February 14, 2014

RE:
Diversified Communications
Renovation and Tenant Improvement
121 Free Street, Portland Maine

A1.02

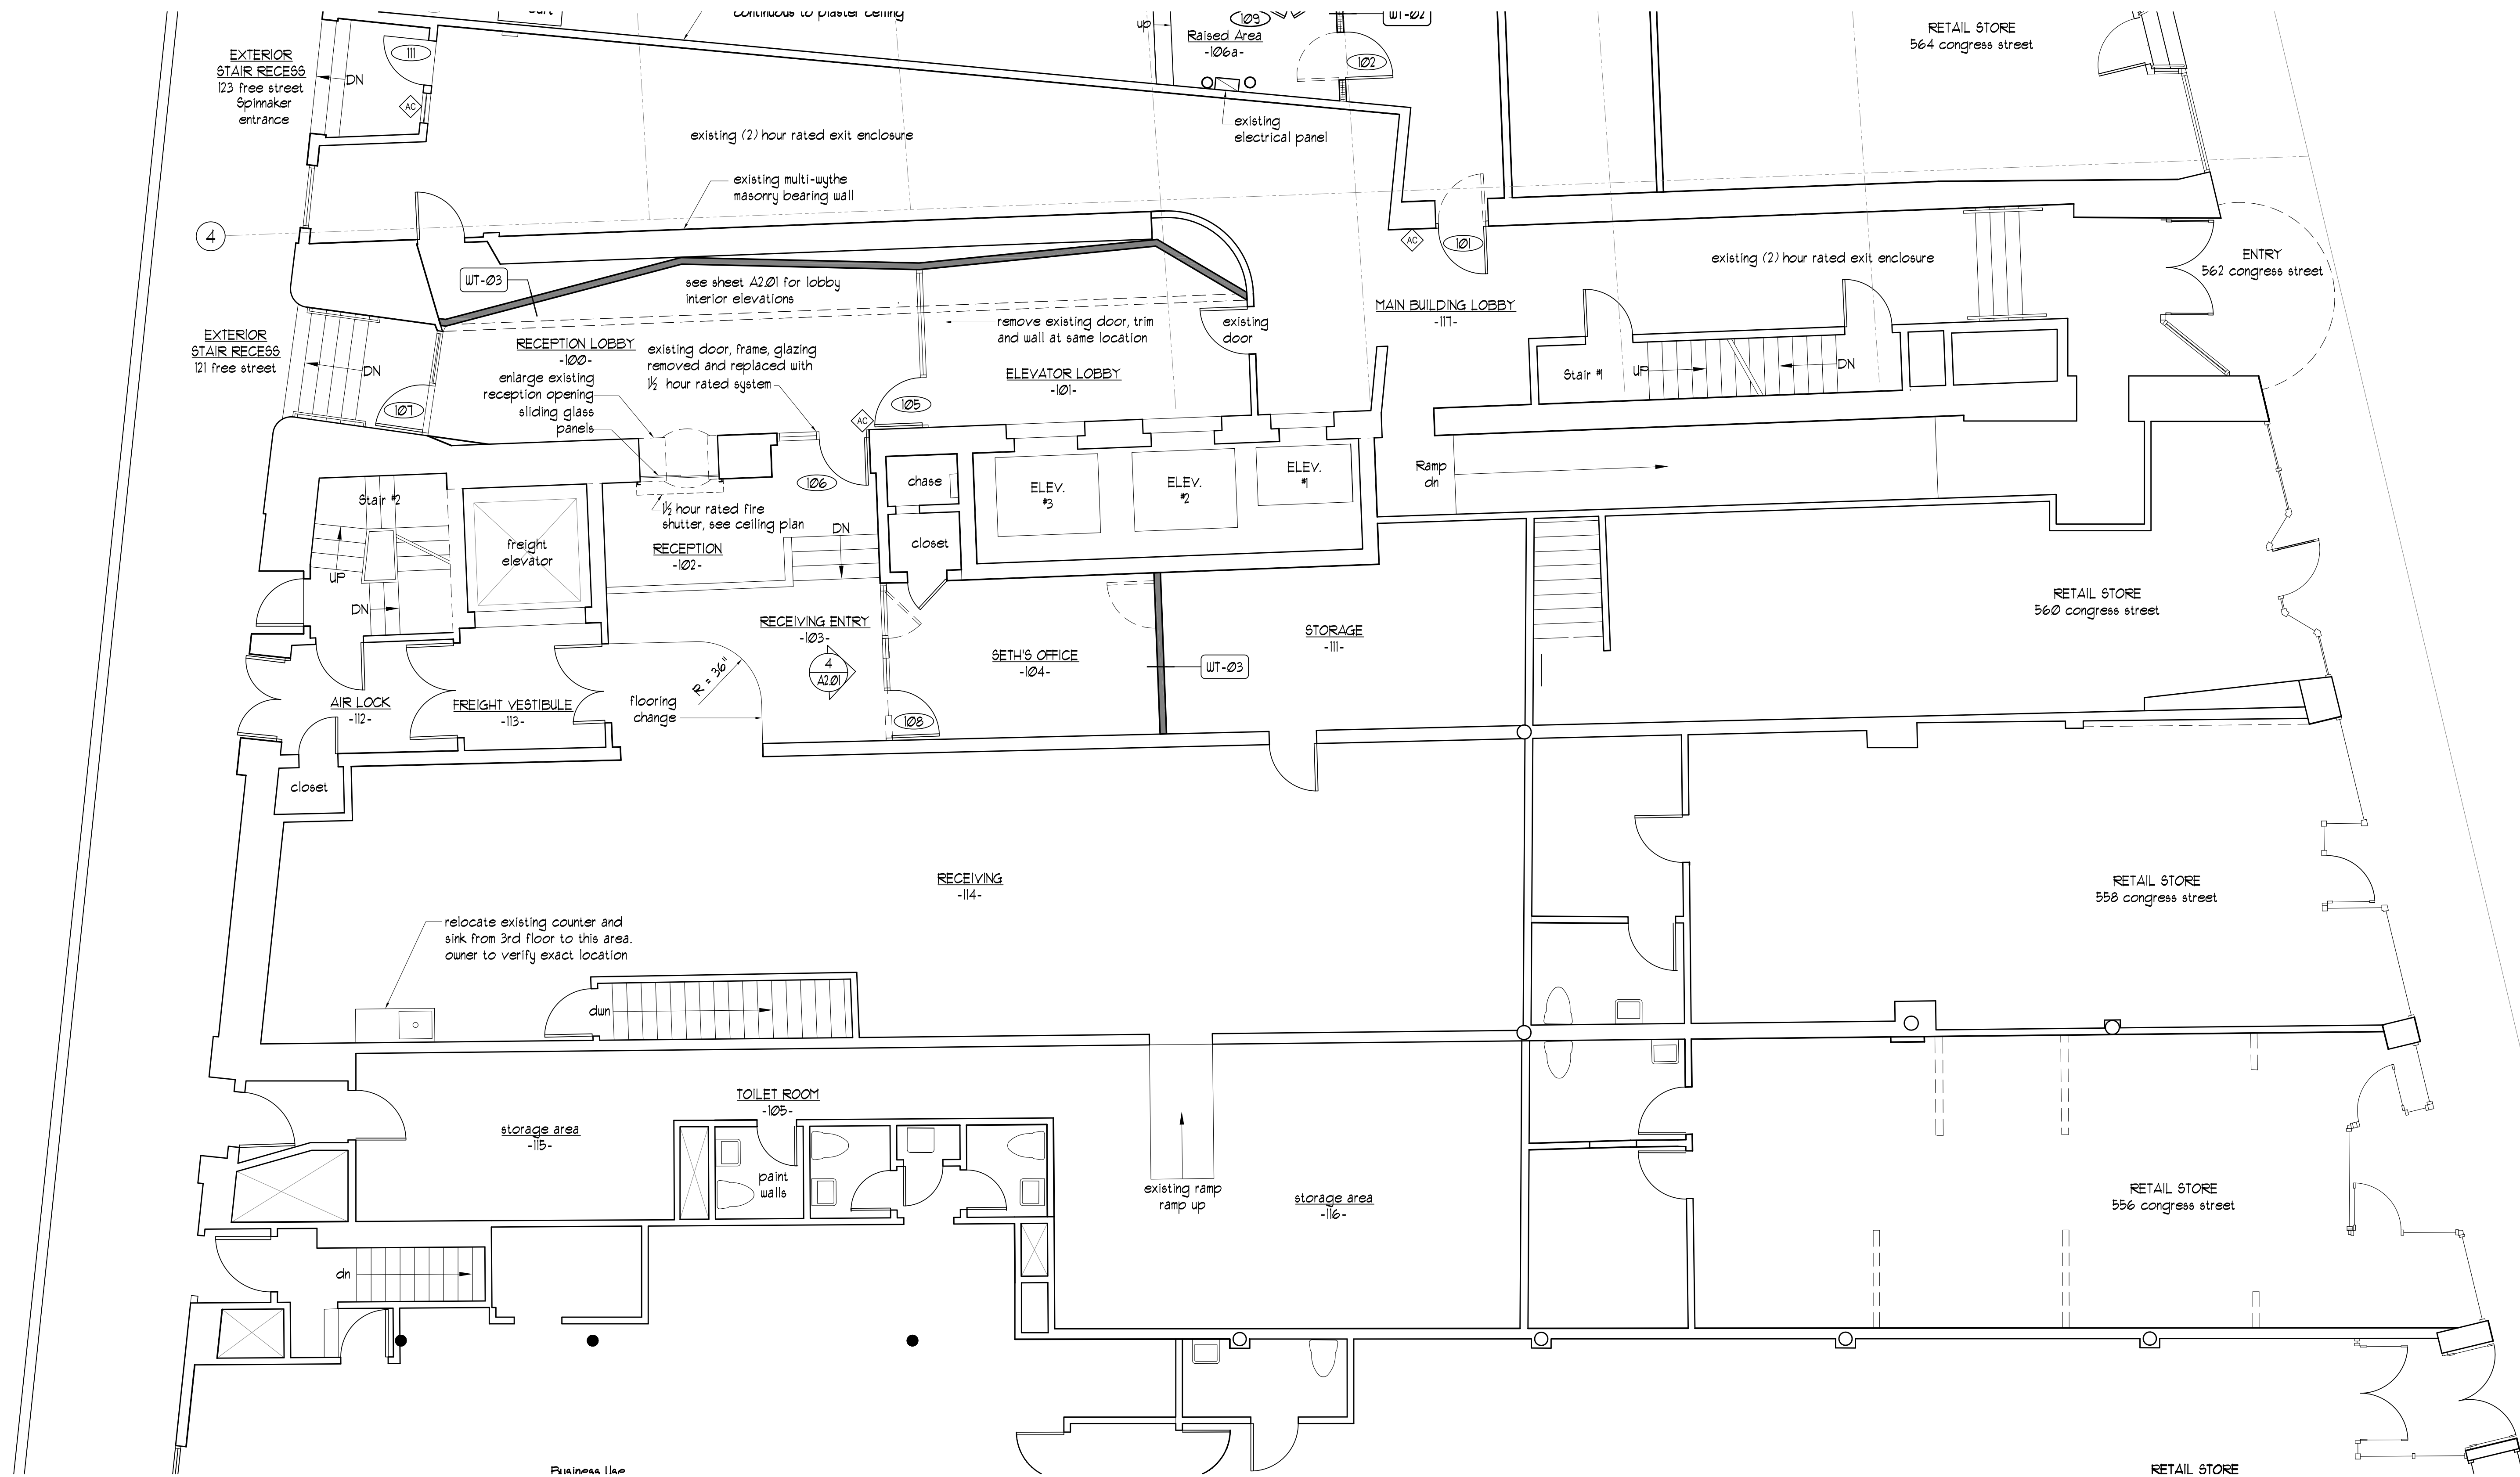
Please provide the following Steel lintels at the new openings in the masonry wall called for on sheet A1.02 at the new openings for doors 207 and 201:

Steel lintel for rough openings (up to 6'-0") in brick walls are L5x3 1/2x5/16 LLV. One L for each 4" of wall thickness. 6" bearing at both ends.
